24-C-1
211 Marginal Way
Bayside East
Tranum & Co.

RE: 211 Marginal Way (Strictly Formal site); CBL 24-C-001; Appl. i.d. #2003-0046

On April 18, 2003 the Portland Planning Authority granted minor site plan approval for certain revisions to 211 Marginal Way (Strictly Formal site). The approval is subject to the following conditions.

6 RIP RAP / GUARD RAIL  
NOT TO SCALE

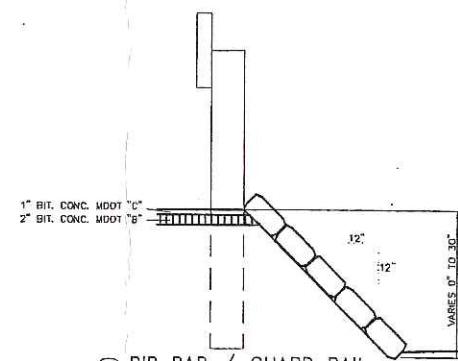
1. A curb or guardrail shall be installed along the AAA side of the parking lot with a design reviewed and approved by the Planning Division.
2. The parking space closest to Marginal Way shall be deleted from the site plan unless an acceptable guardrail is reviewed and approved by the Planning Division.

**SITE PLAN**  
1" = 20'-0"

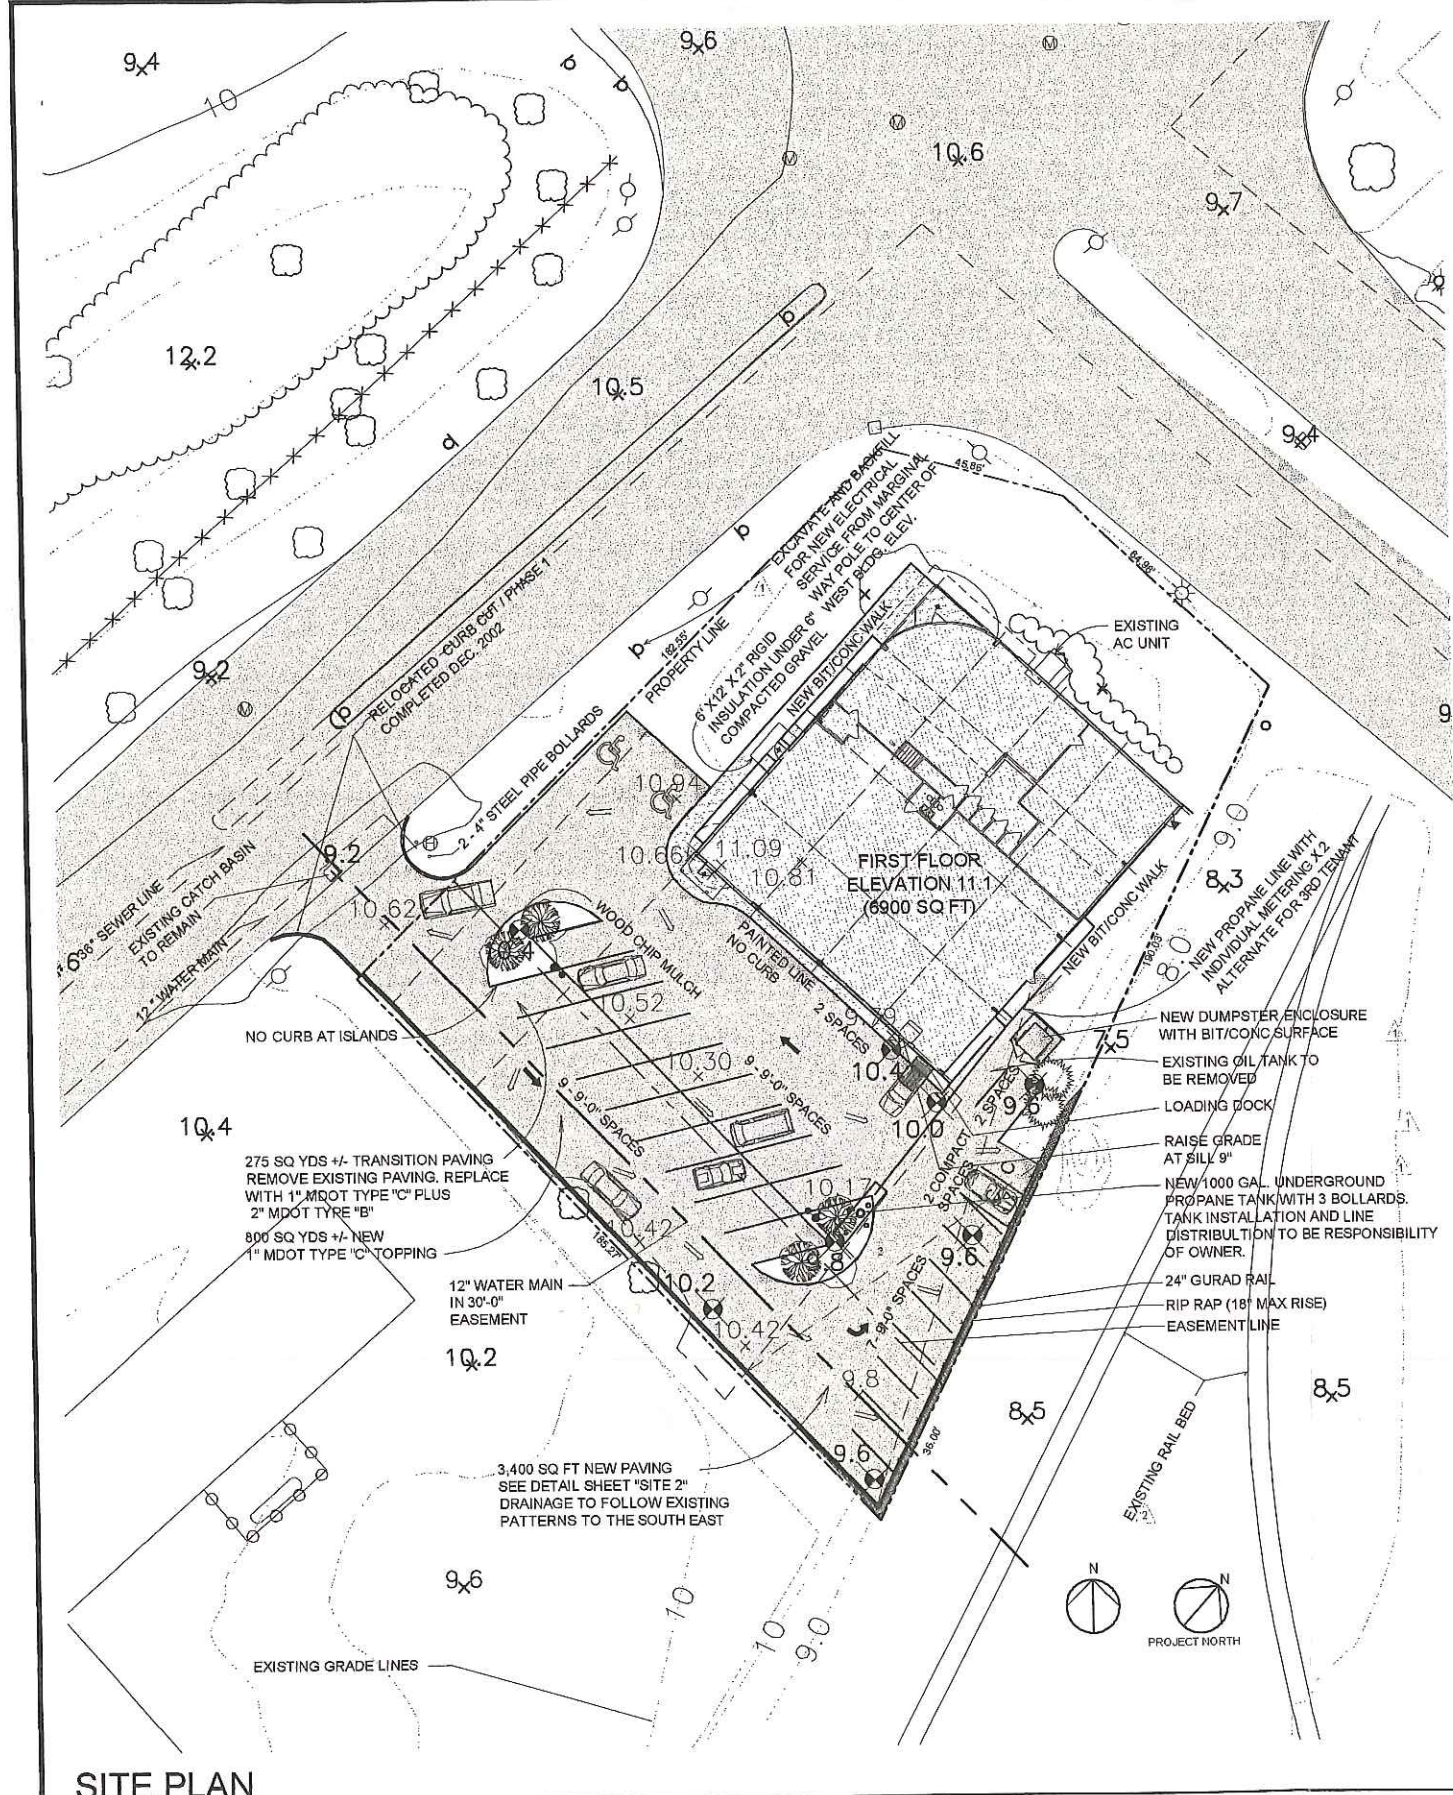
3. A "do not enter" sign shall be added on the left hand side of the entrance per Jim Seymour's comments dated April 2, 2003.
4. The existing catch basin in the middle of driveway shall be relocated as required by Anthony Lombardo of Public Works. Installation details shall be submitted for review and approval.

5. A six-foot concrete sidewalk shall be installed along the applicant's Marginal Way street frontage with a five-foot wide esplanade. In areas where the sidewalk occupies land on private property, the applicant shall submit a sidewalk easement for City staff review and approval. Construction details of the sidewalk shall be submitted for review and approval.

6. Given the uncertainty of the specific design for the Franklin Street reconstruction, the applicant may choose from one of the following:
 - (a) Construct a six-foot wide bituminous sidewalk with a five-foot esplanade along the applicant's Franklin Street frontage. Construction details of the sidewalk shall be submitted for review and approval.
